Our ref: HA/2020/122302/01
Your ref: LU/135/20/DOC
Date: 24 June 2020

**APPROVAL OF DETAILS RESERVED BY CONDITION IMPOSED UNDER REF
LU/63/11 RELATING TO CONDITION NO 16 - SURFACE WATER DRAINAGE.**

LITTLEHAMPTON FITZALAN LINK ROAD, LITTLEHAMPTON.

We have reviewed the following information submitted in regard to the application for the discharge of Condition 16 of planning permission ref: LU/63/11:

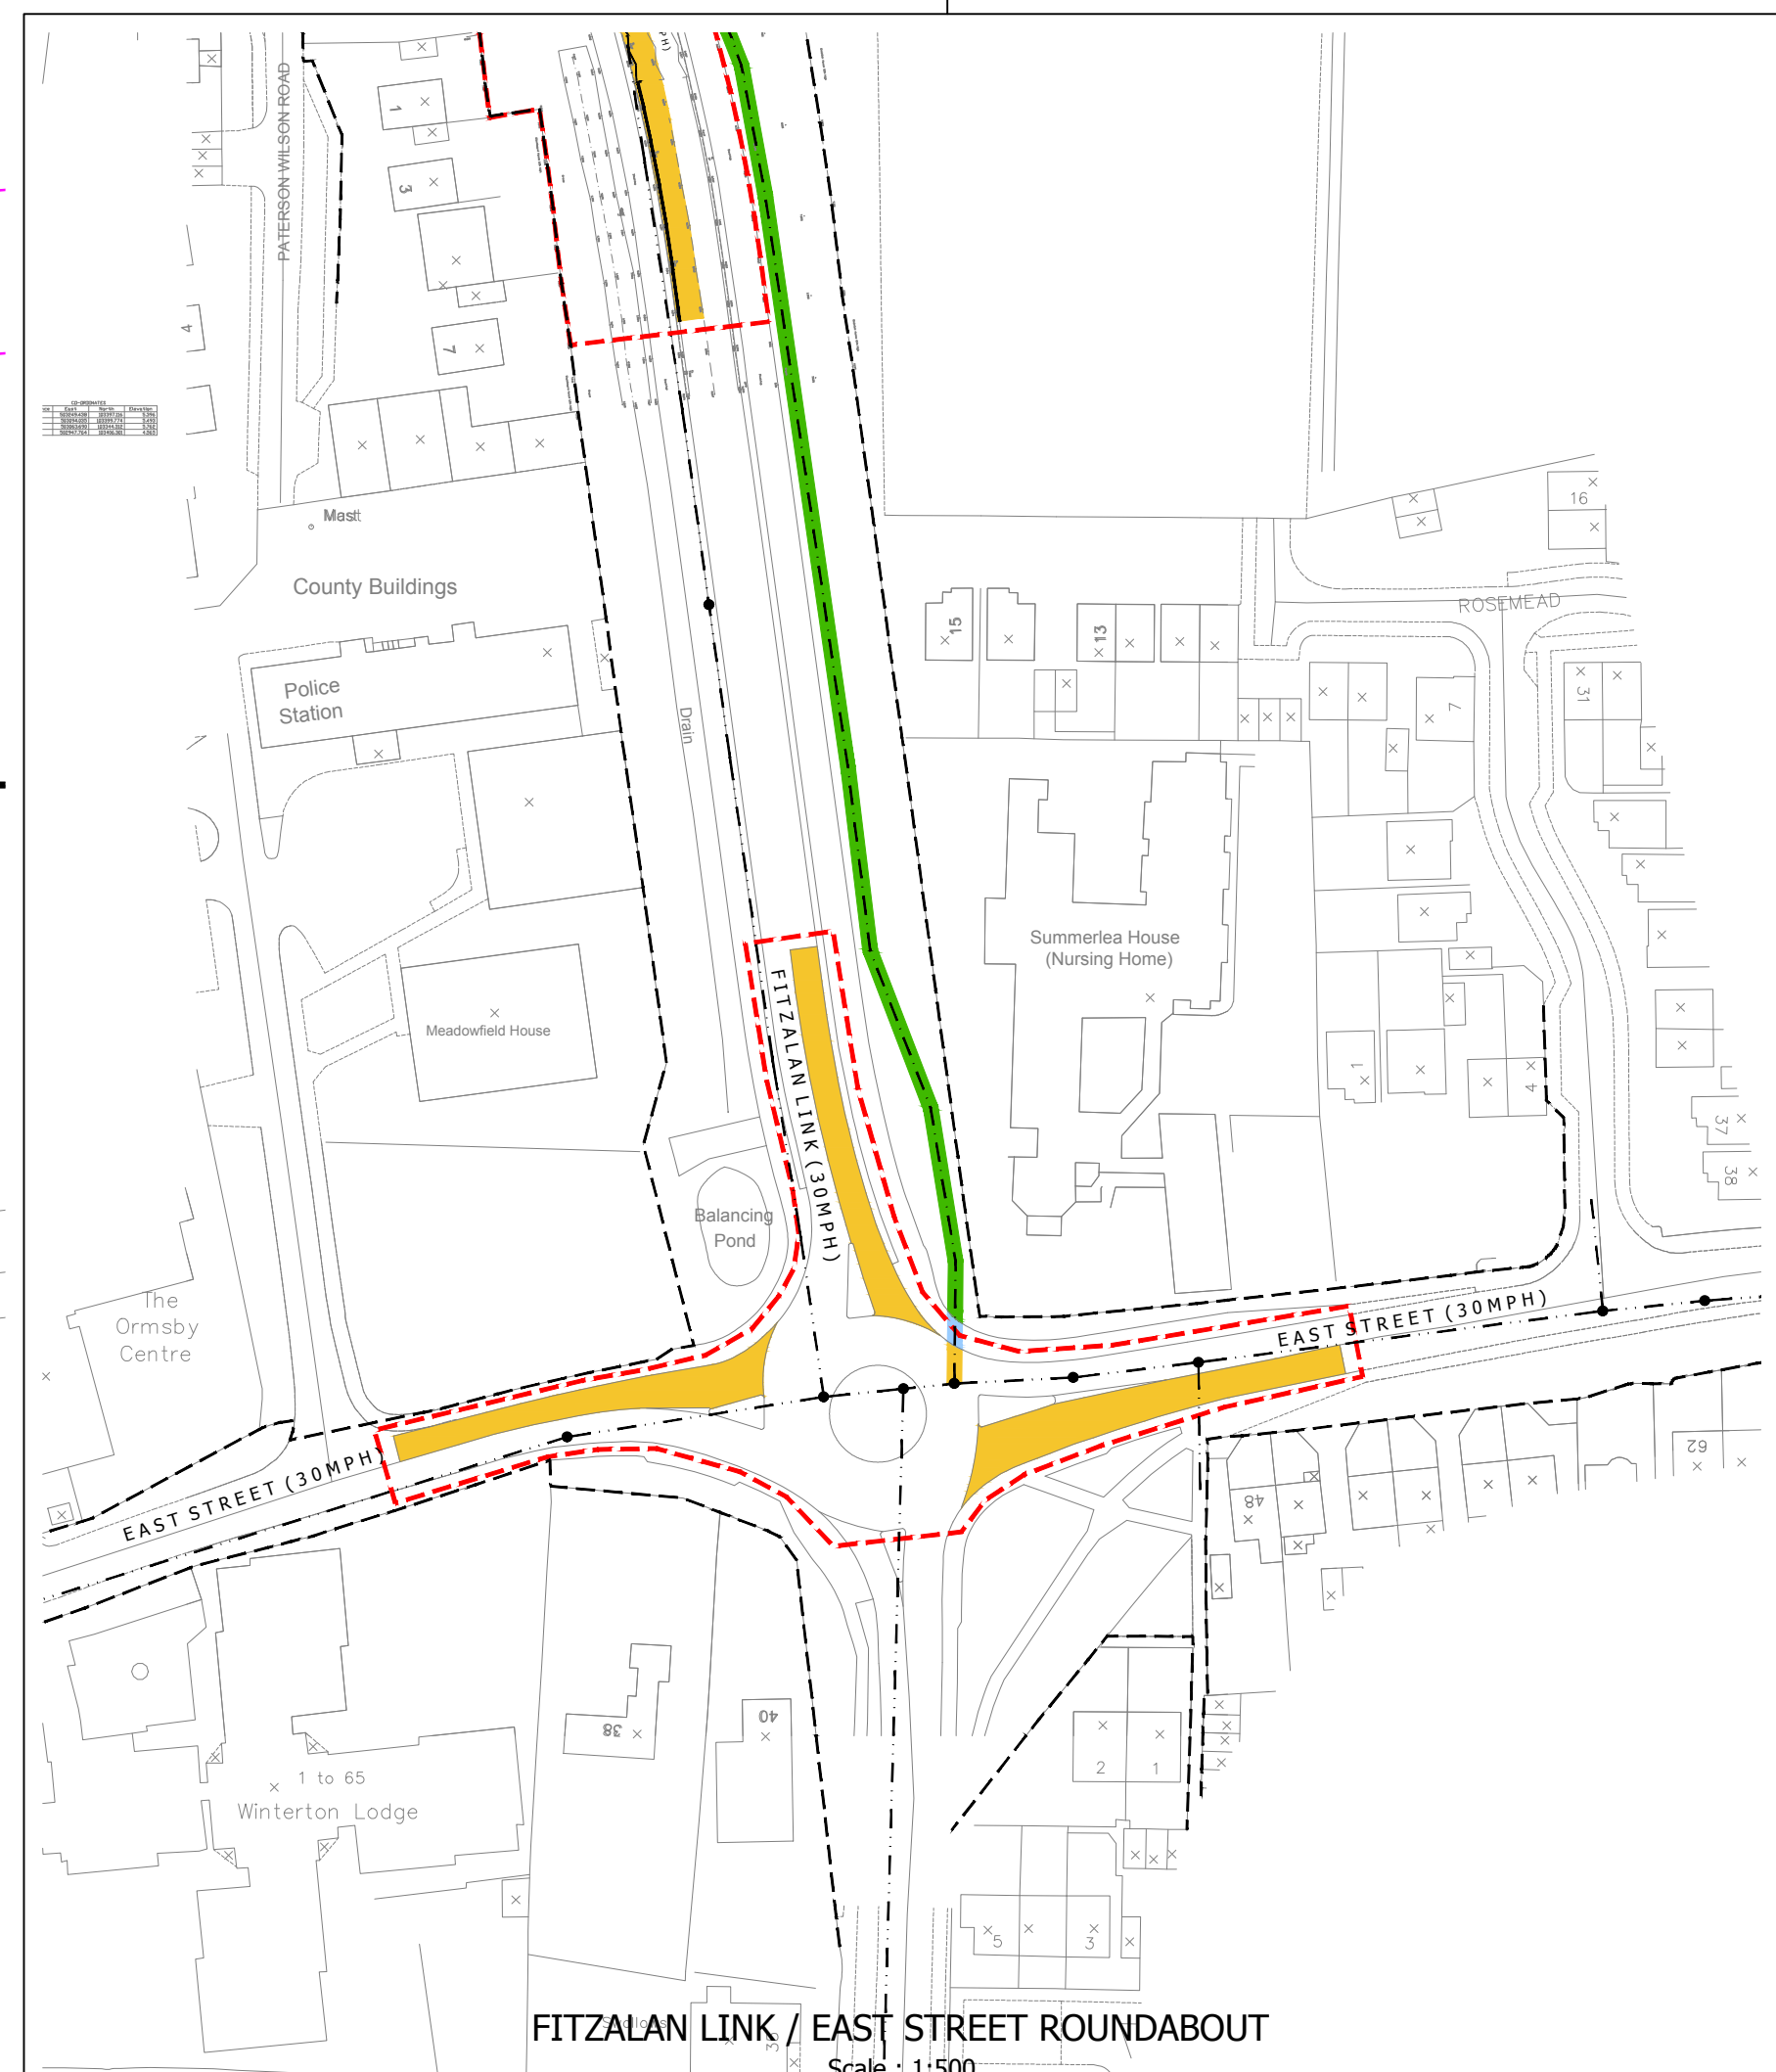
- Two drawings (refs: PHF-MB-S278-GF-DR-D-S278-01 Rev P9 and PHF-MB-S278-GF-DR-D-S278-02 Rev P9) as provided to us by email dated 4 June 2020 from Mr Michael Eastham (Principal Planning Officer, Arun District Council); and
- An email dated 4 June 2020 from Mr Robert Clark (Head of Planning, Persimmon Homes Thames Valley), confirming *"that surface water will drain to an adopted highways drain and will not affect a river/ watercourse."*

Based on the information submitted, we are able to recommend that Condition 16 can be discharged if the Local Planning Authority are satisfied also. We are pleased that the proposals have been altered, and discharge of surface water is now via underground tanks to an adopted highway drain.
